MEMORANDUM

TO: Jeff Watson, Community Development Services
FROM: Christina Wollman, Planner II *CW*
DATE: June 16, 2010
SUBJECT: Tomich SG-10-00010

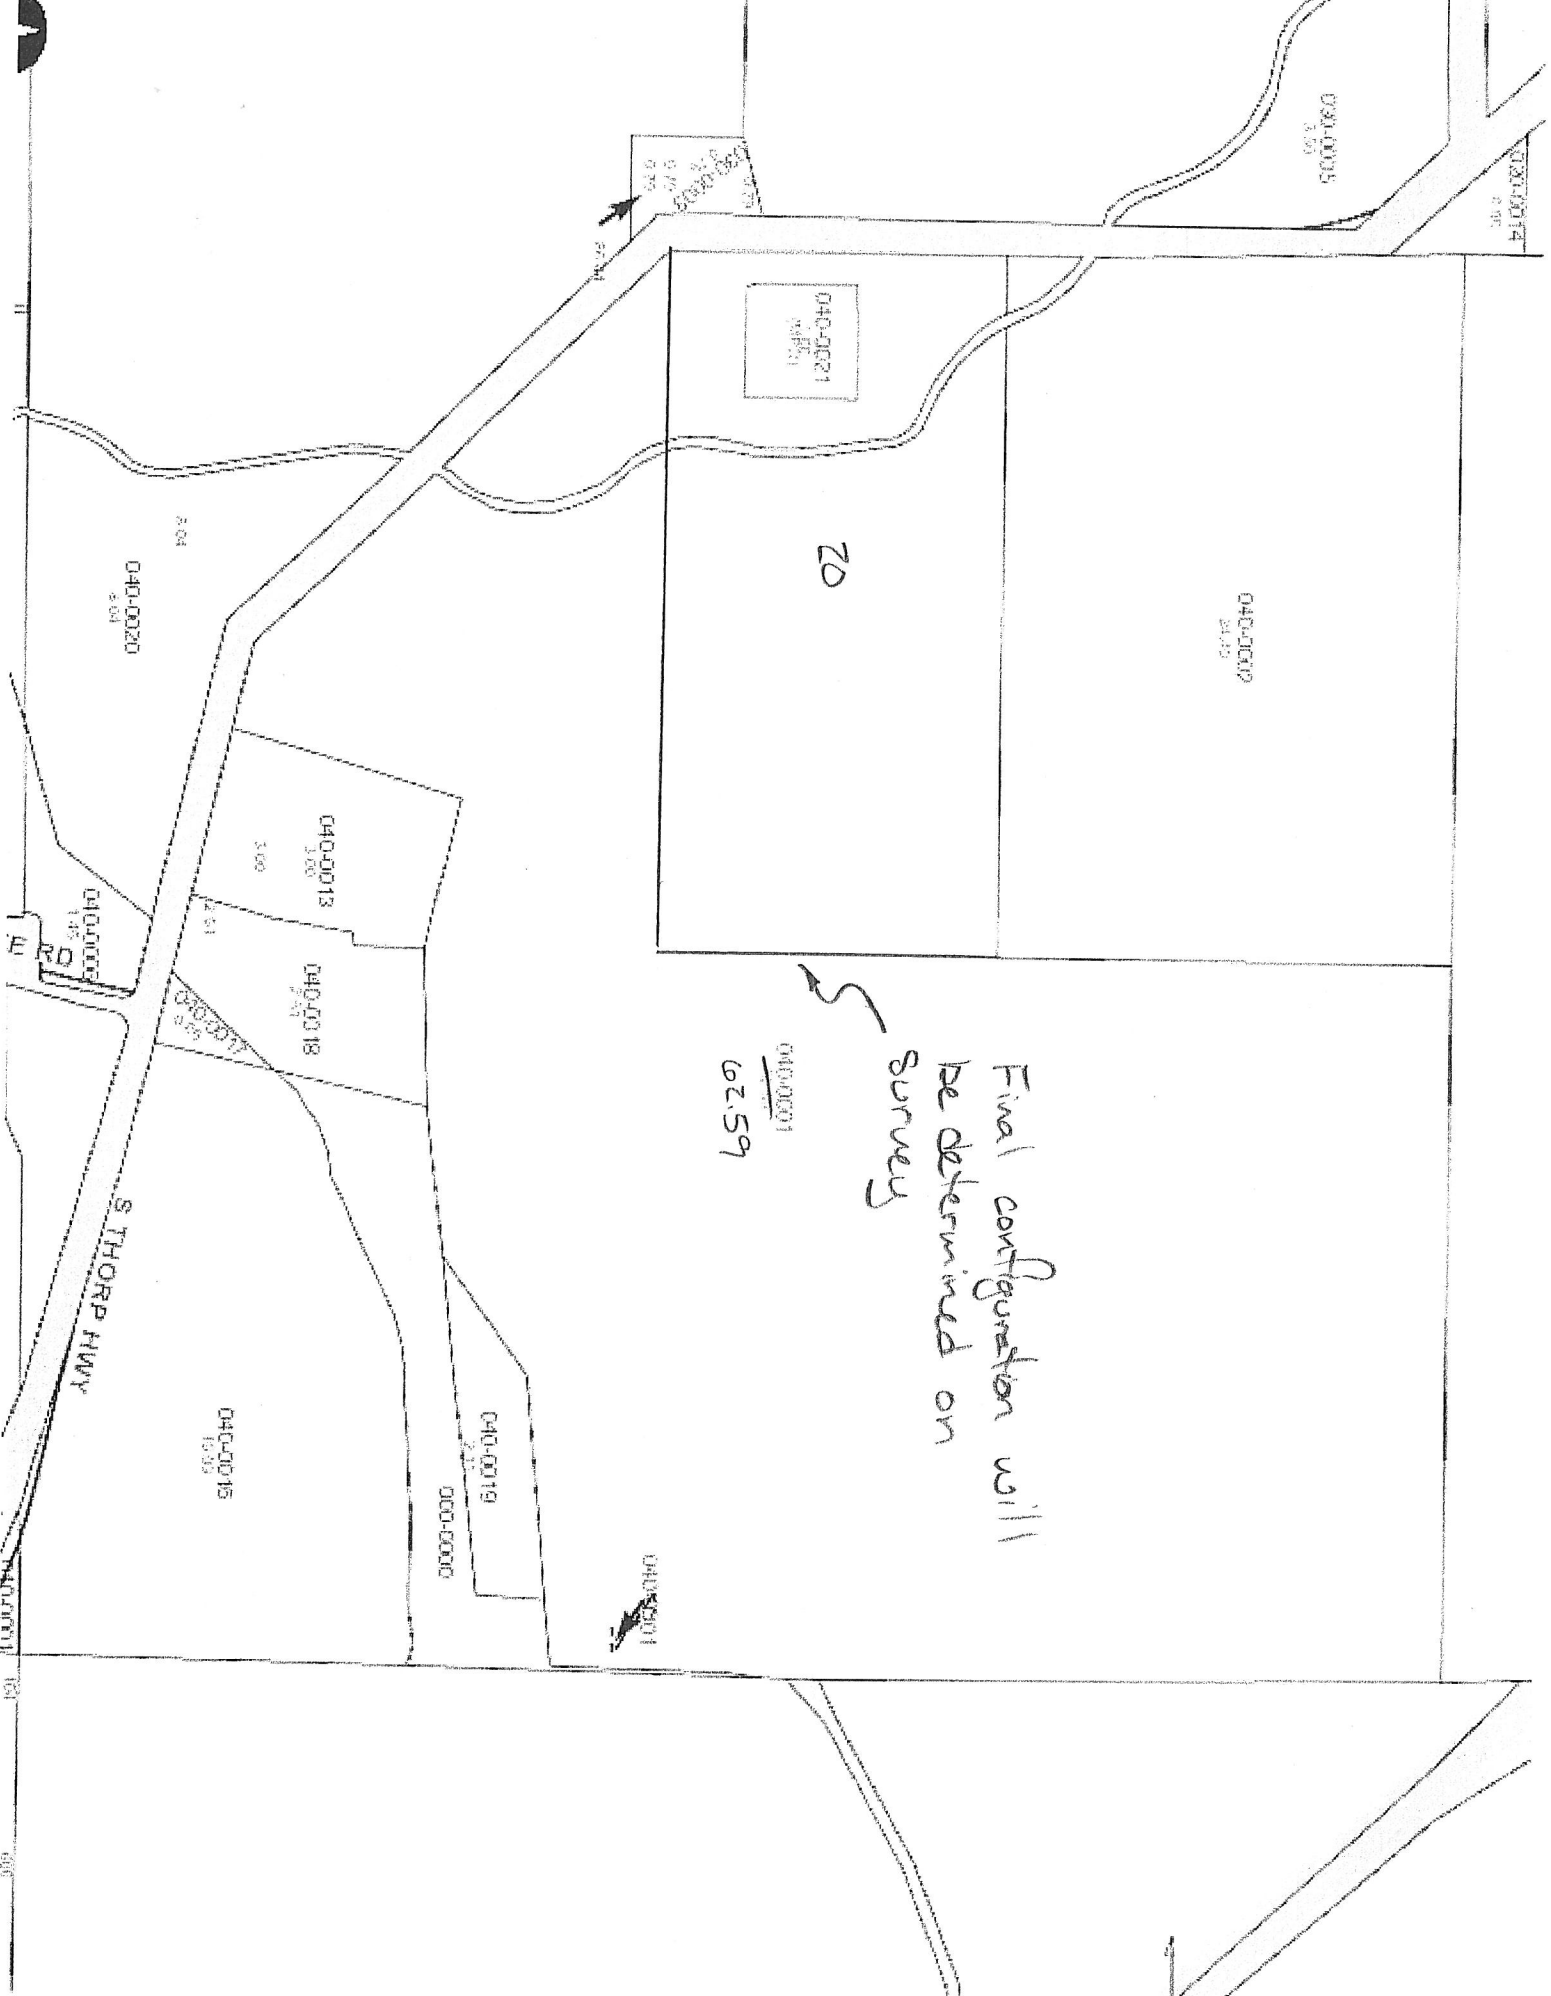
- a. The existing agricultural access at the south end of the lot does not meet current Kittitas County Road Standards. The access may continue to be used as an agricultural access. However, the use of this access cannot be changed to a residential access in the future.
- b. An approved Access Permit shall be required from the Kittitas County Department of Public Works prior to creating any new driveway access or performing any work within the County Road Right of Way.
- c. Maintenance of driveway approaches shall be the responsibility of the owner whose property they serve. The County will not maintain accesses.
- d. Any further subdivision or lots to be served by proposed access may result in further access requirements. See Kittitas County Road Standards.
- e. Access is not guaranteed to any existing or created parcel on this application.
